WALBERTON PARISH COUNCIL INCLUDING FONTWELL AND BINSTED

Ref: Planning Application WA/5/22/PL - Morelands, Arundel Road, Fontwell BN18 0SB

Walberton Parish Council wishes to **object** to this planning application in its current form.

TITLE
**Building B -
Elevations**

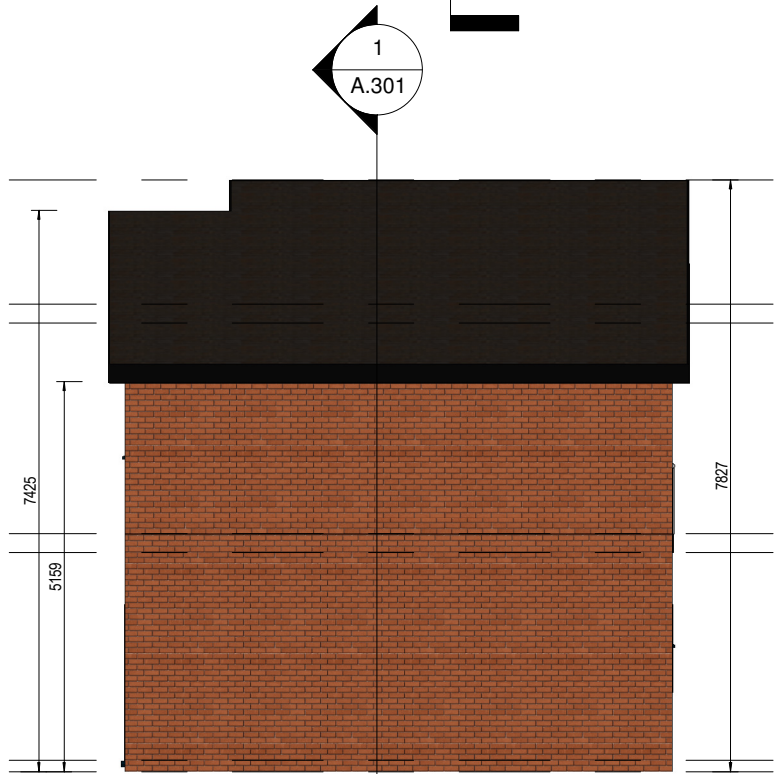
- We note that the appearance, especially the first-floor balconies, is not in keeping with the immediate locality.
- The parking provision does not appear to be adequate, in that when cars occupy both of a pair of spaces access to and egress from vehicles may not be possible. The long driveway may cause conflict between (for example) refuse vehicles and the increased number of vehicles on site, necessitating long reversing manoeuvres onto Arundel Road.
